Re: ABP case reference : PAX07.323761

Applicant : Neoen Renewables Ireland Limited

Located within the townlands of Cloondahamper, Cloonascragh, Elmhill, Cooloo, Lecarrow, Dangan Eighter, Lissavally and Slievegorm, Co.Galway

In ABP case reference **323761** to which this observation refers, the applicant has, as one can see in Map 1, next page, ignored the turbine separation distances from adjacent turbines, that are recommended in the WEDG2006 guidelines.

PROJECT TITLE: Cooloo Wind Farm, Co. Galway		
DRAWING TITLE: Site Layout Key Plan (1:2,500)		
PROJECT No.: 190723	DRAWING No.: 190723 - 06	SCALE: 1:20,000 @ A3
DRAWN BY: JOB	CHECKED BY: RD	DATE: 24.09.2025
		REVISION.: P01
OS SHEET No.: 2816, 2817, 2884, 2885, 2953, 2954

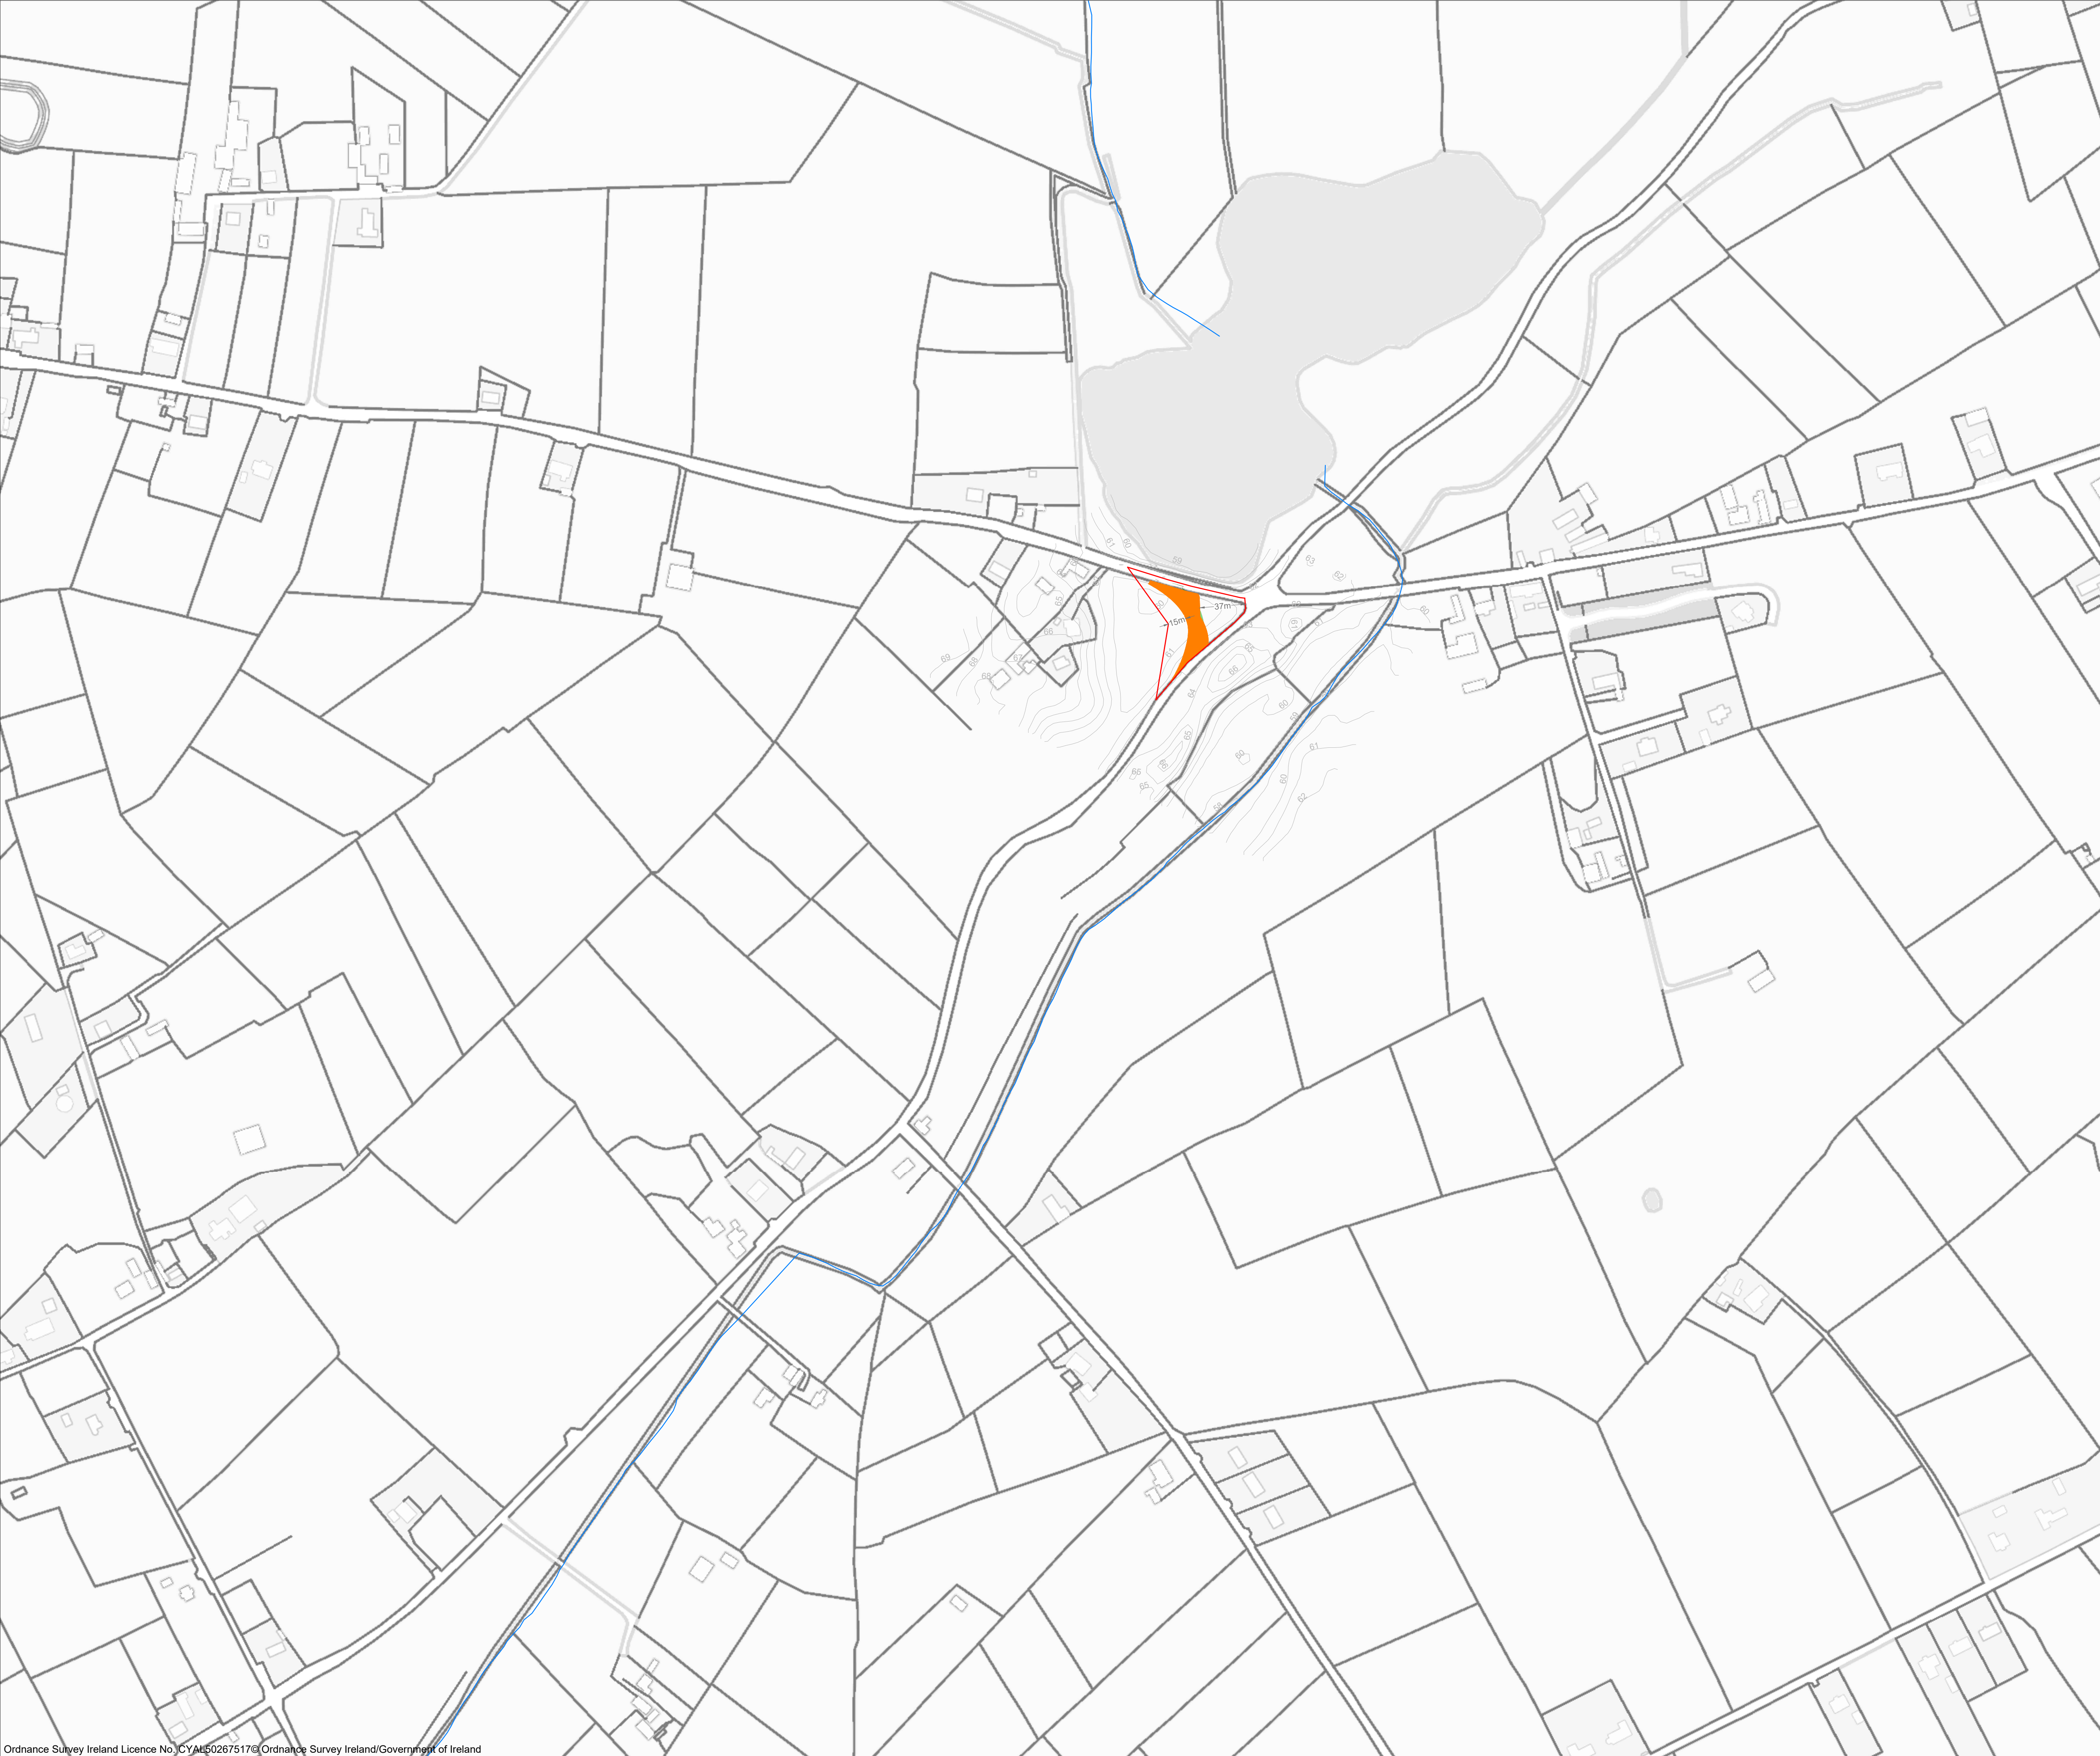
The following turbine spacing arrangements fail the required WEDG 2006 guidelines.

Failing turbine sets:

Less than 7 RD are T3 to T6.

Less than 6 RD are T5 to T9 & T6 to T7.

Less than 5 RD are T5 to T8, T2 to T4.

Less than 4 RD are T1 to T2, T2 to T3, T3 to T4, & T8 to T9.

The software used by designers of windfarms ignore the WEDG2006 guidelines for turbine to turbine spacing within a windfarm. Therefore excessive wind shear, turbulence, noise and a lack of output capacity (efficiency) will occur.

On the basis of what I have outlined and experienced, I highly recommend the aforementioned issues be carefully considered, and the design be altered significantly.
